RESPONSE TO PLANNING RELATED TO PLANNING APPLICATION A/266/21PL

Planning has received a number of comments from residents around the above application site. Each of these representations seem to identify common elements so I have summarised the main issues below and have prepared a response as to how we are trying to resolve these matters to make this development acceptable within planning guidelines.

SOUTH (REAR) ELEVATION
1:100

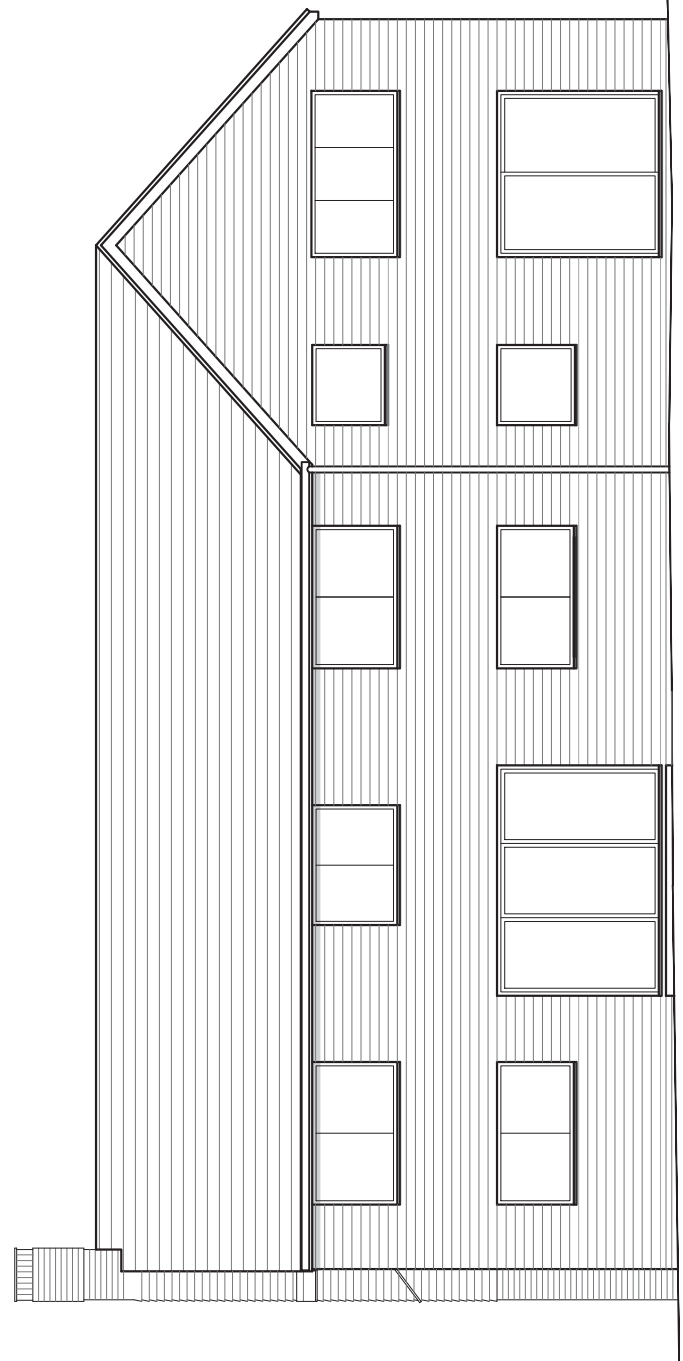
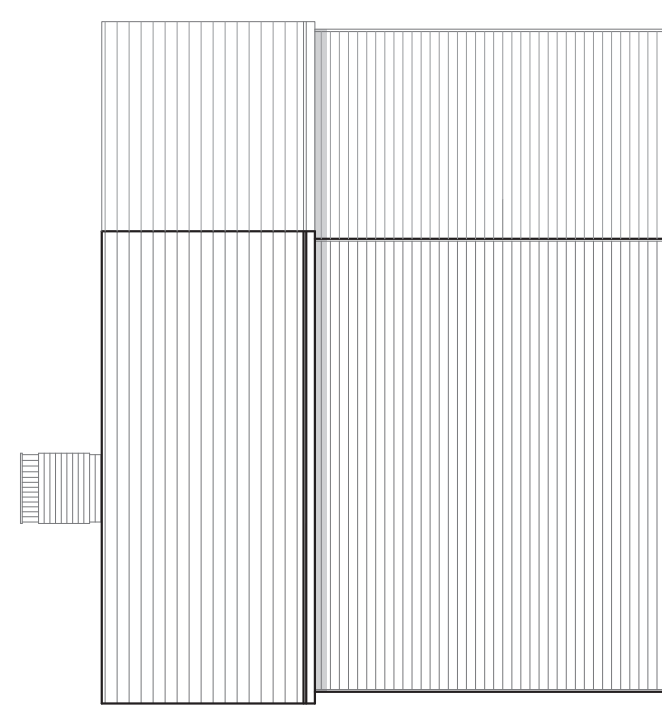
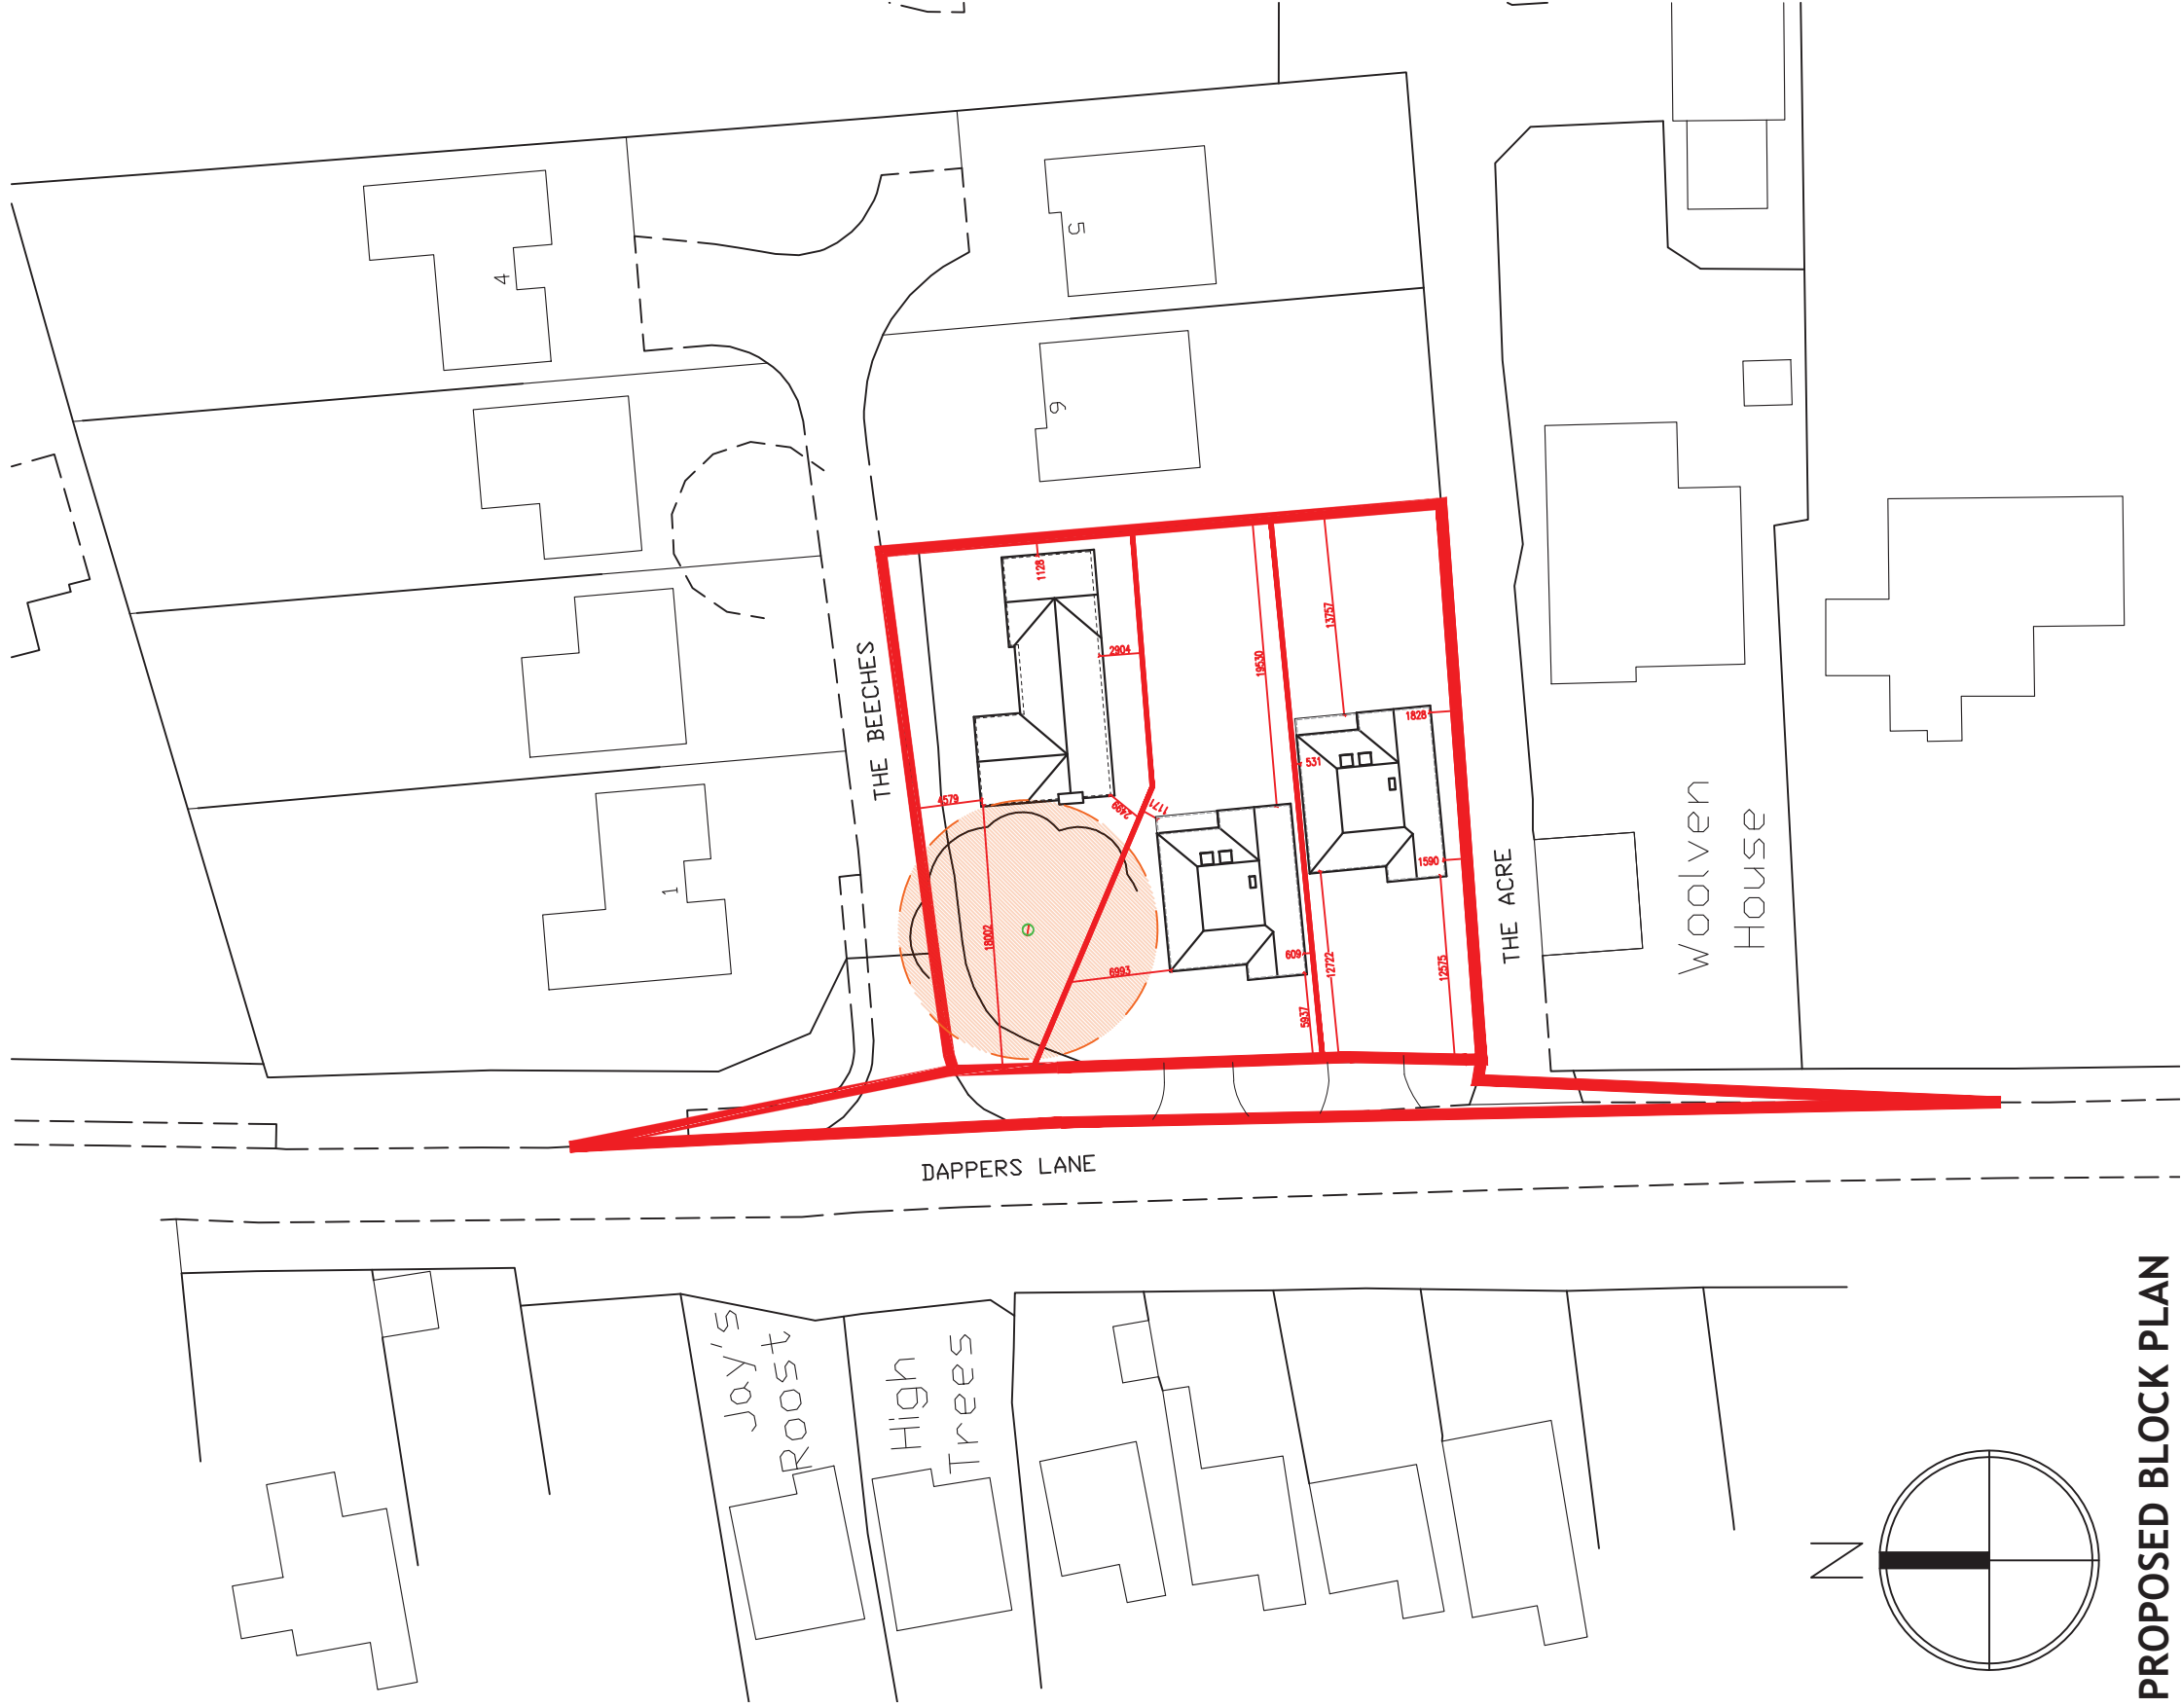
Overlooking:

We are not proposing any windows in the Eastern elevation to the new extension to Crete house so there are no overlooking issues with number 6 from Crete house.
